**Subject:** August 2nd Development Facilitation Team (DFT) Comments for PR-2021-006208

Attached are DFT comments for **item # 1, PR-2021-006208**.

CLIENT: BW GAS & CONVENIENCE RETAIL, LLC  
ALLSUP'S CONVENIENCE STORE #102460  
9501 GIBSON BLVD SW  
ALBUQUERQUE, NEW MEXICO 87121  
FINAL ENGINEERING PLANS  
SITE LAYOUT PLAN

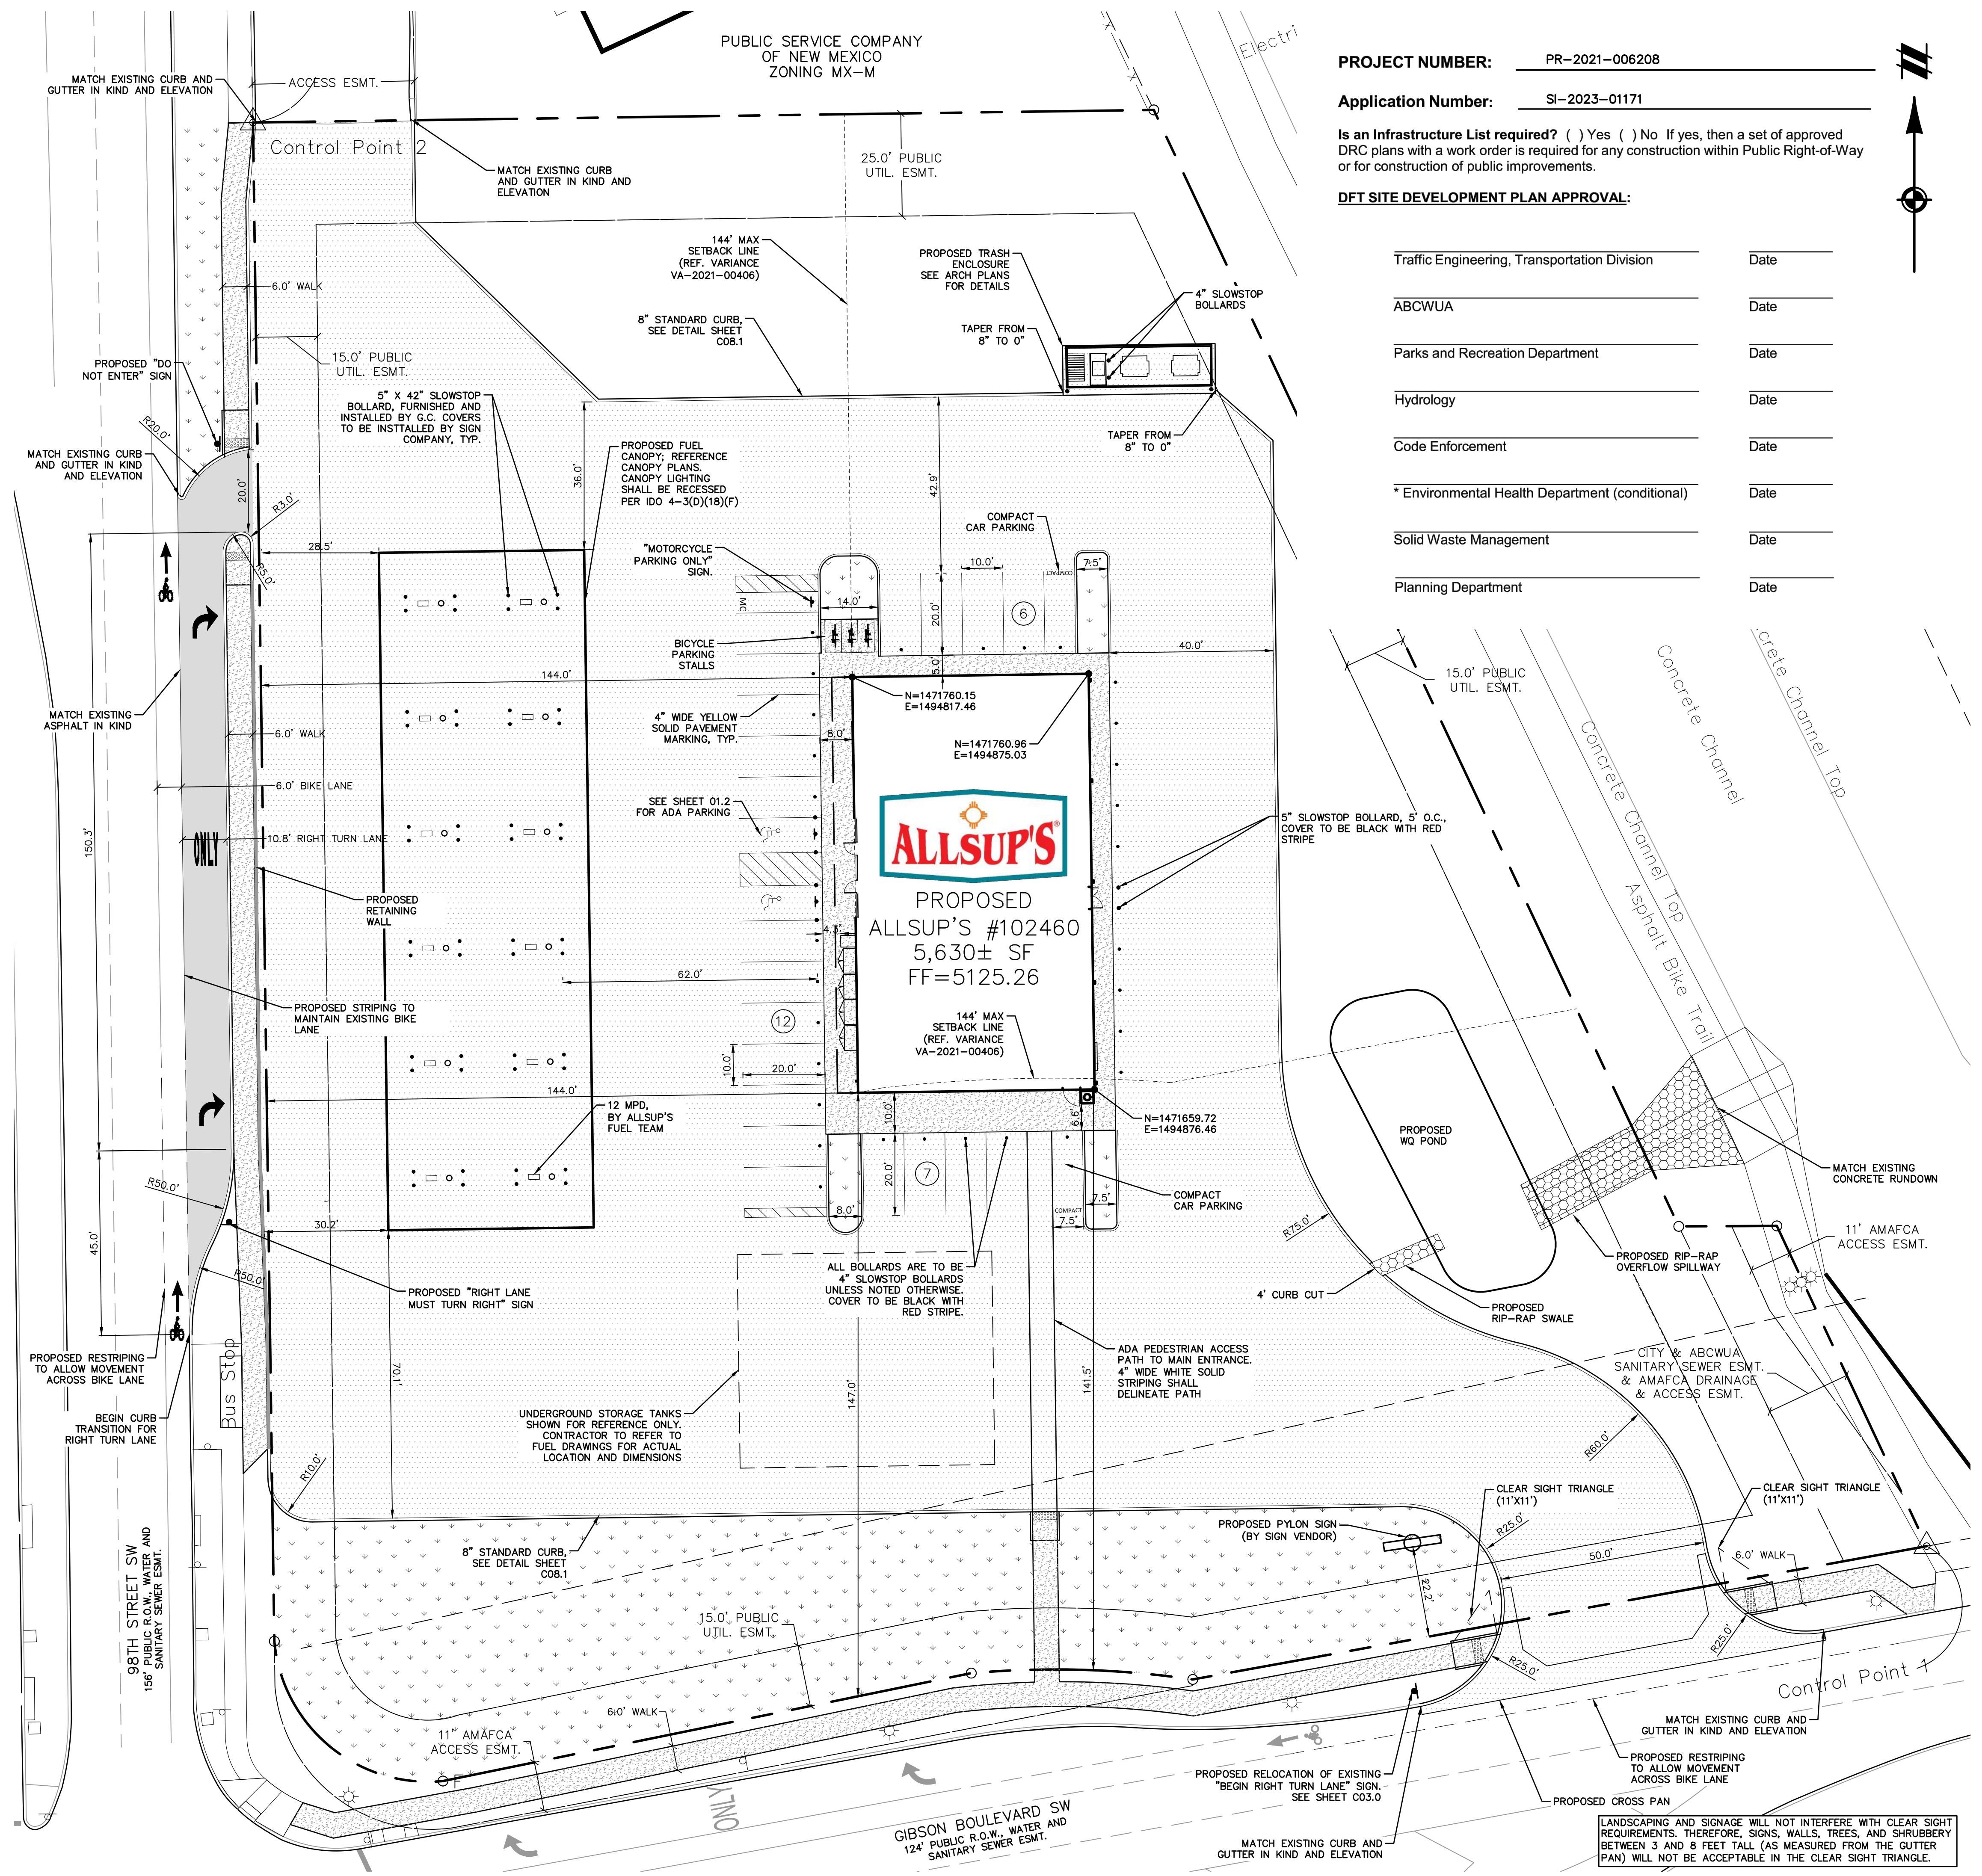
We will need to assess what additional ROW will be required to accommodate a 10’ multi-use trail north of the sidewalk with appropriate buffering from the sidewalk. We will expect this to be added to the infrastructure list and constructed via work order.

Just to verify, we will not be proposing a 6' sidewalk shown on our plans along Gibson; rather we will be proposing a 10 multi-use trail?

Please calculate at least a minimum distance of 2' from the sidewalk for a 10' asphalt trail with an additional 2' on the north side of the trail. (Minimum 14') Once that number has been calculated, please add any additional ROW required to the plat, identify the alignment of the trail with buffers per the DPM via a section detail. It will also need to be added to the infrastructure list. I will verify whether we can add it into the project and do a Procedure C or if we will request construction of the trail.

“The City’s roadway project is federally funded; therefore, we are unable to make any modifications to the approved plans. We coordinated with the developer of Alsups throughout our design, so they will only be required to provide a Procedure C for the additional right turn lane, curb and gutter, 6’ sidewalk and any ROW that would need to be dedicated to maintain public improvements within City ROW.

The roadway project will connect to the existing sidewalk at the NE corner of 98<sup>th</sup> and Gibson and construct new sidewalk east to meet the existing sidewalk/drivepad located at the channel and per the approved City plans.”
